APPLICATION NO. 03DRB-02100	PROJECT NO. 1003/87
PROJECT NAME IOWANA ADDN.	
EPC APPLICATION NO.	
APPLICANT / AGENT ABQ. ENG. INC	PHONE NO. 255-7802
ZONE ATLAS PAGE L-19 Prelim #	
(SDP for SUB), (SDP for BP), (FINAL PLATS), (MASTER DEV PLAN), (IR), (AA)	
ONE STOP COMMENT FORM LOG

RE: Request for Final Plat approval for Tract A New Mexico Central Credit Union.

TRACT A - NEW MEXICO CENTRAL CREDIT UNION

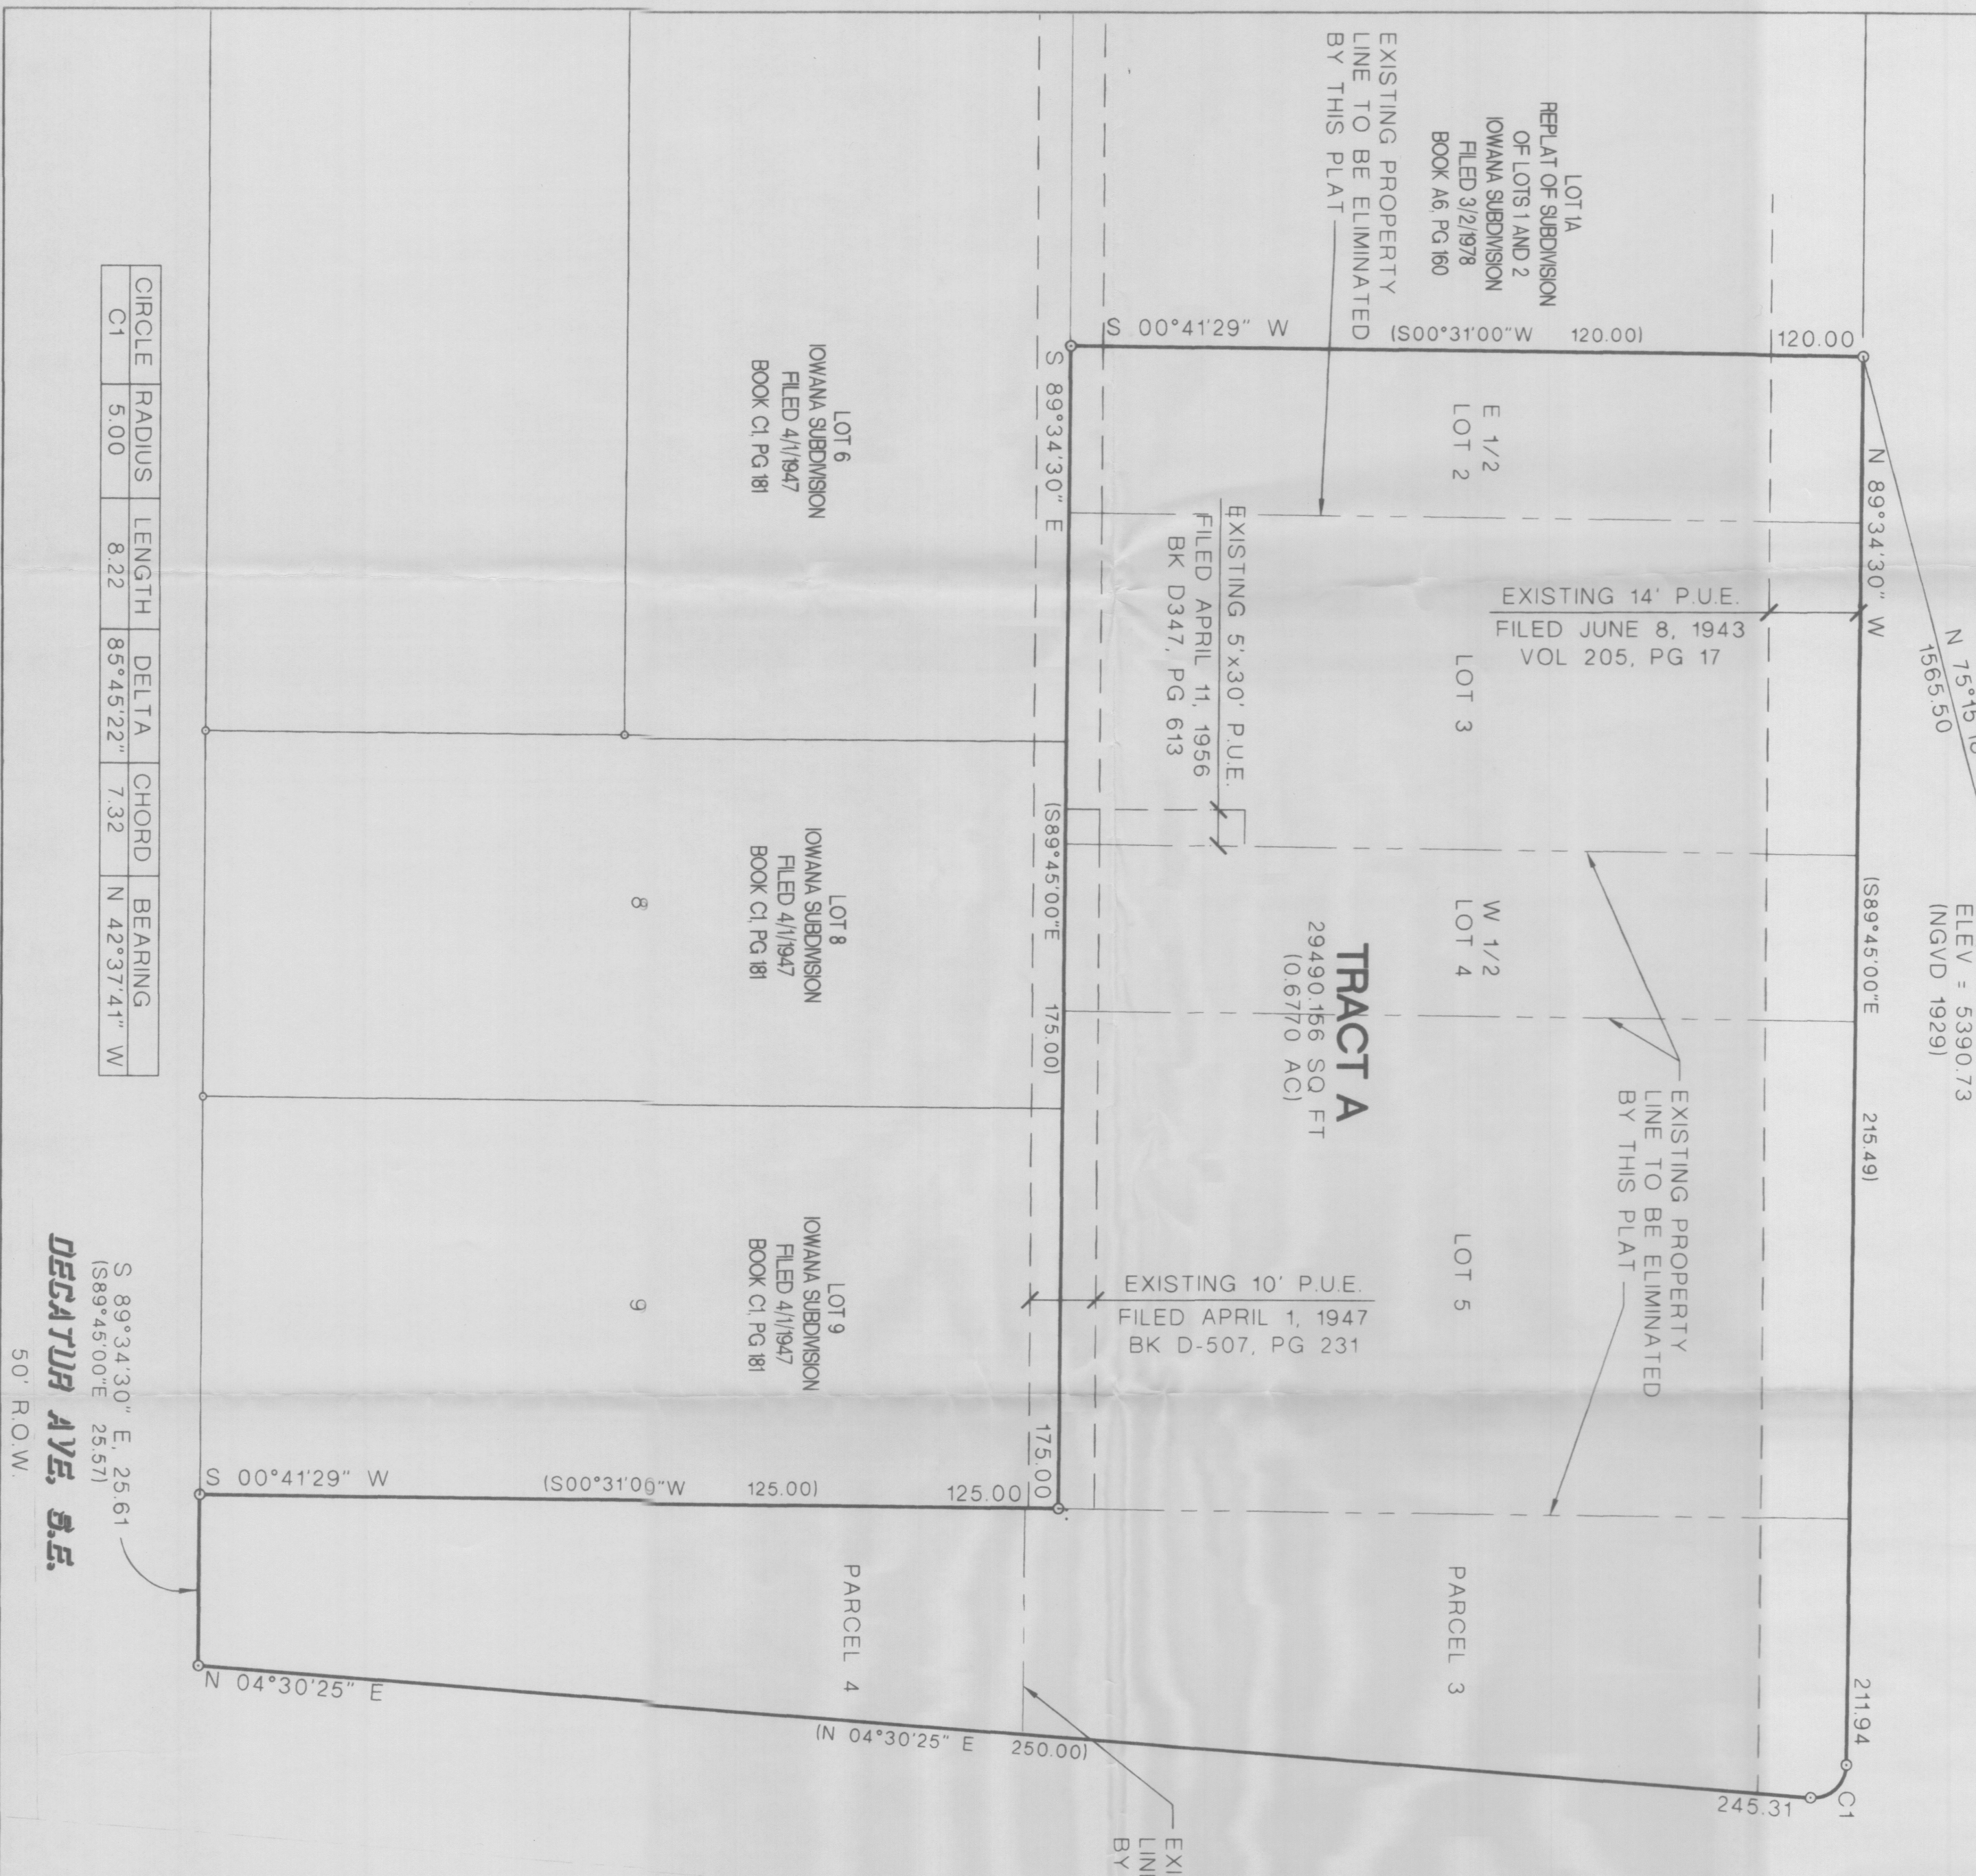
TRANSPORTATION DEV (505) 924-3990		
PLANS DISAPPROVED	DATE	DATE
PLANS APPROVED W/G	DATE 12-16-03	DATE
	DATE 12-22-03	DATE
COMMENTS:		
RADIUS @ INTER & ZUNI SHOULD BE 30'		
(Transp. comment resolved B.A.)
